**REQUEST**

Current Zoning: N1-B (neighborhood 1-B)  
Proposed Zoning: INST(CD) (institutional, conditional)

**SUMMARY OF PETITION**

The petition proposes to develop a 15,000 square foot facility for special needs youth and adults on vacant land.

RZ-2.0

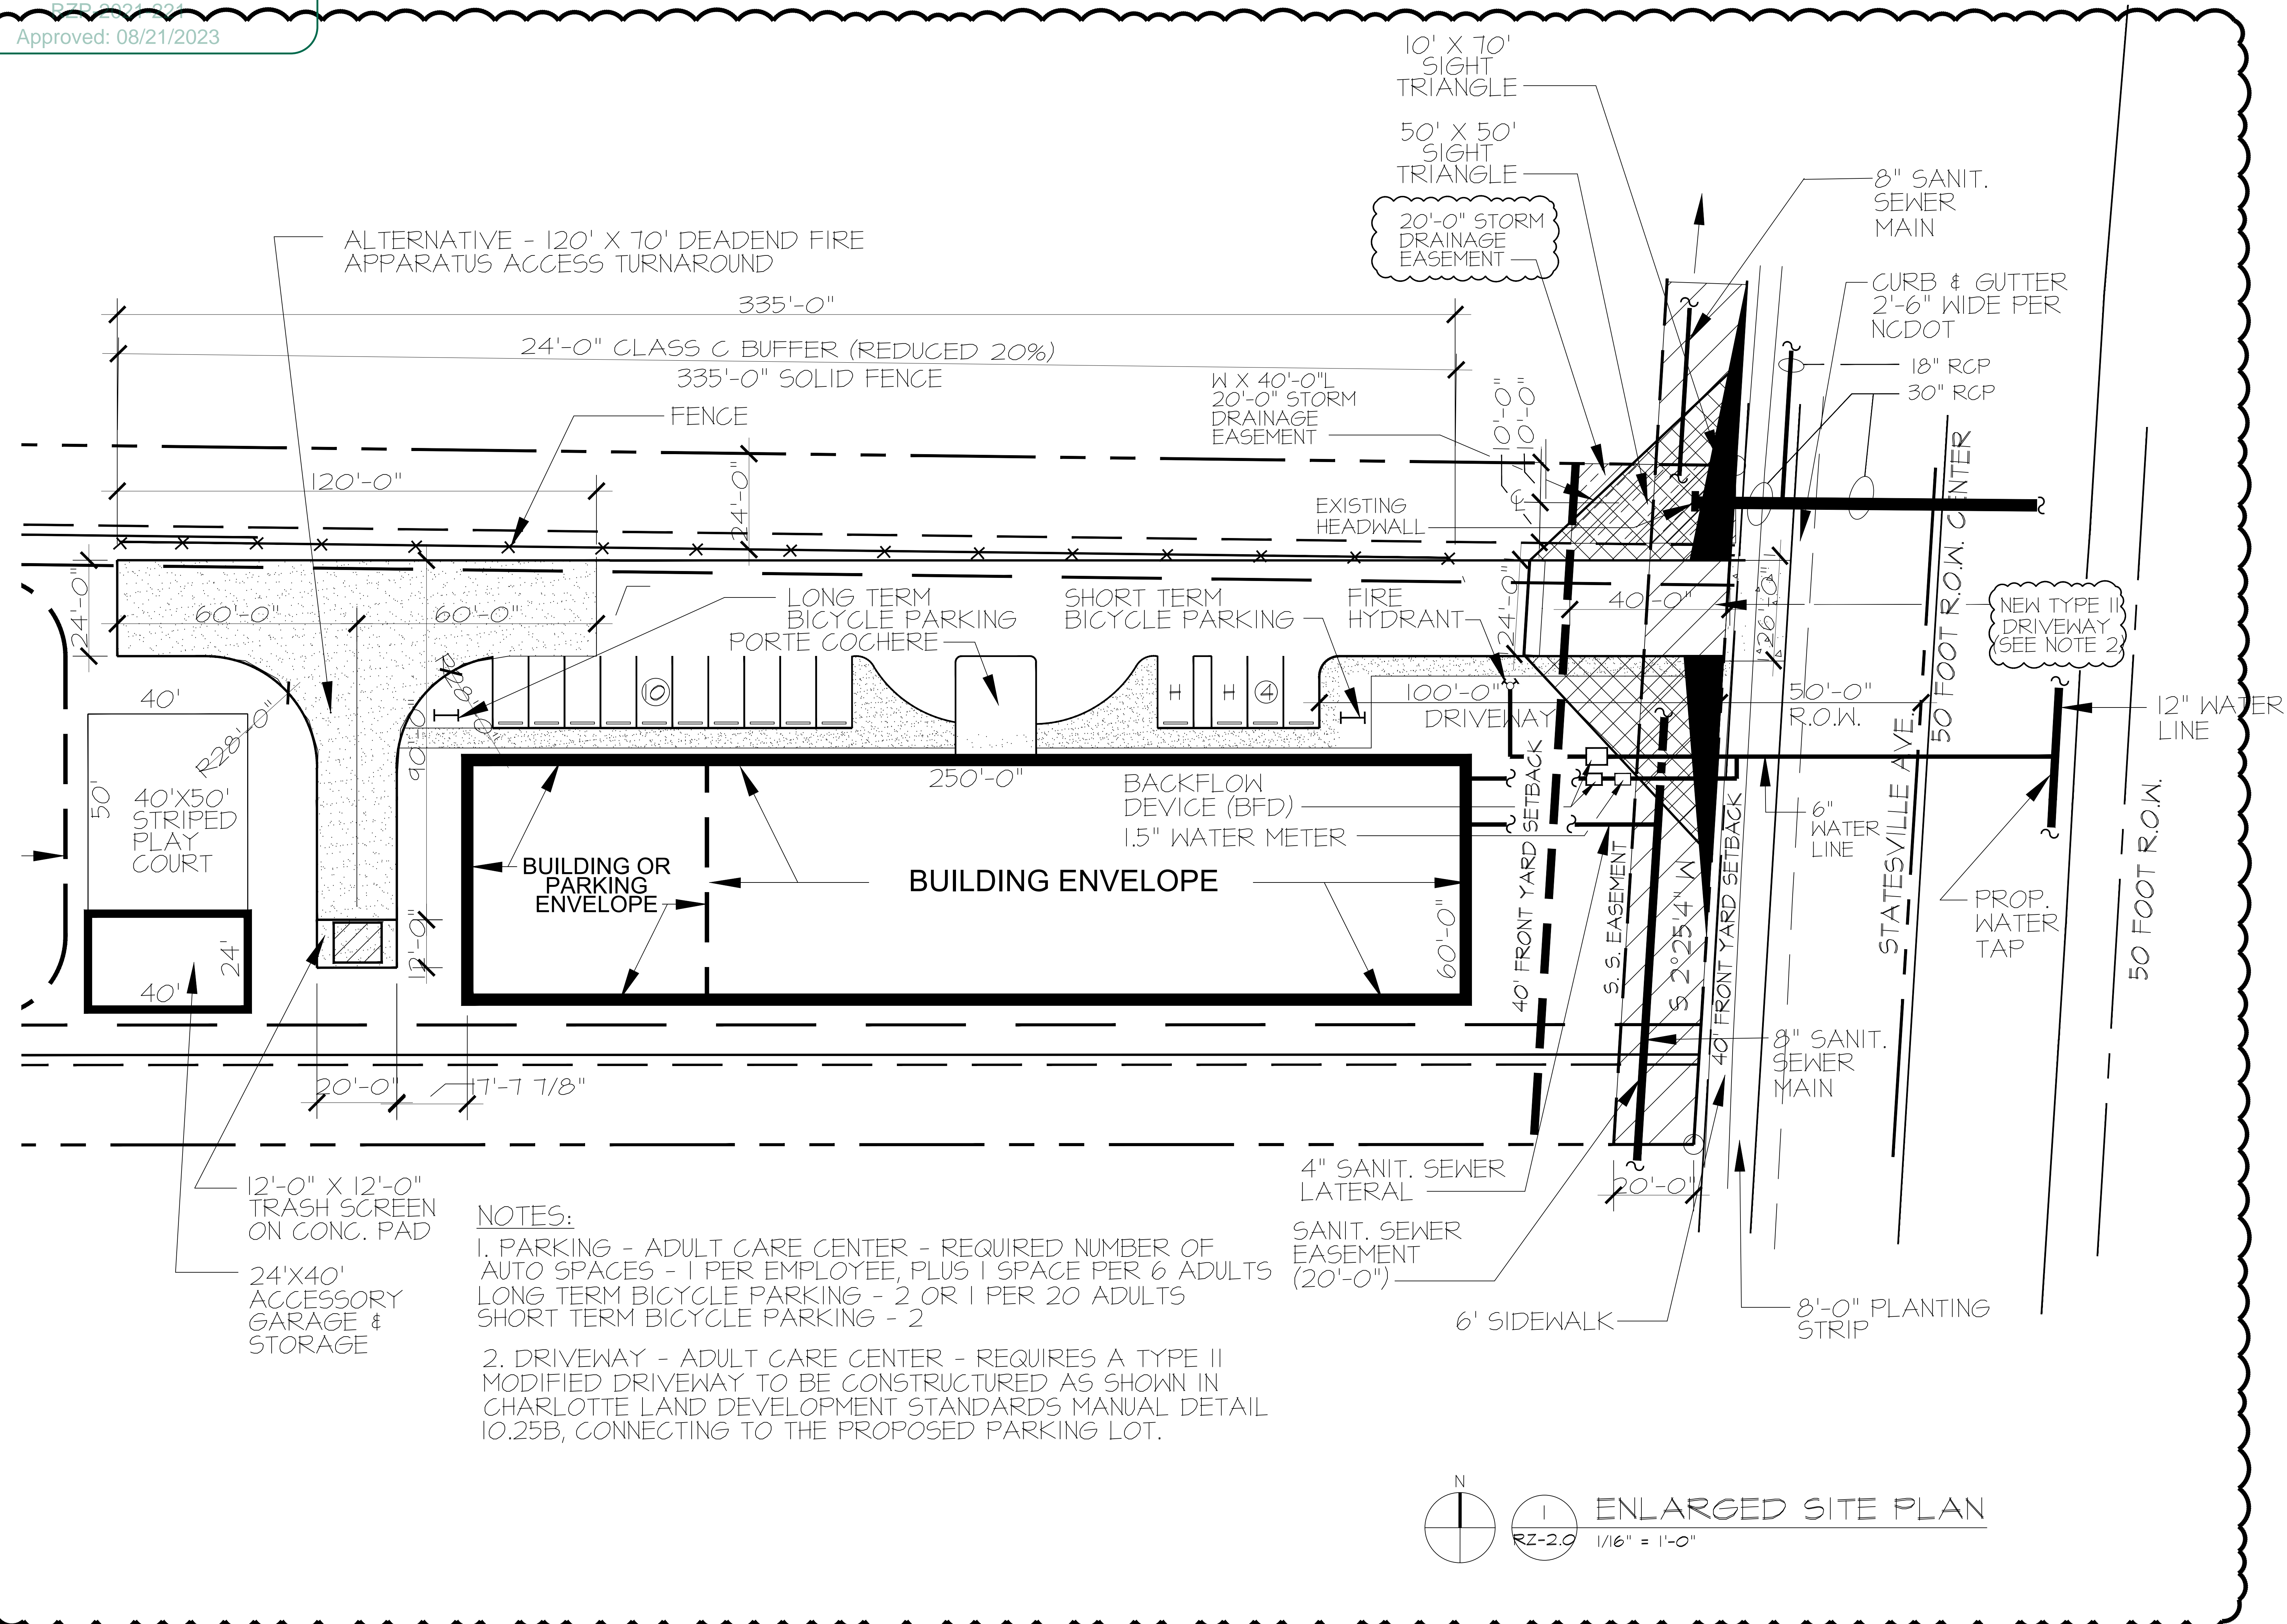
1. Revise site plan and conditional note(s) to commit to construct a Type II Modified driveway as depicted in Charlotte Land Development Standards Manual detail 10.25E connecting to the proposed parking lot.
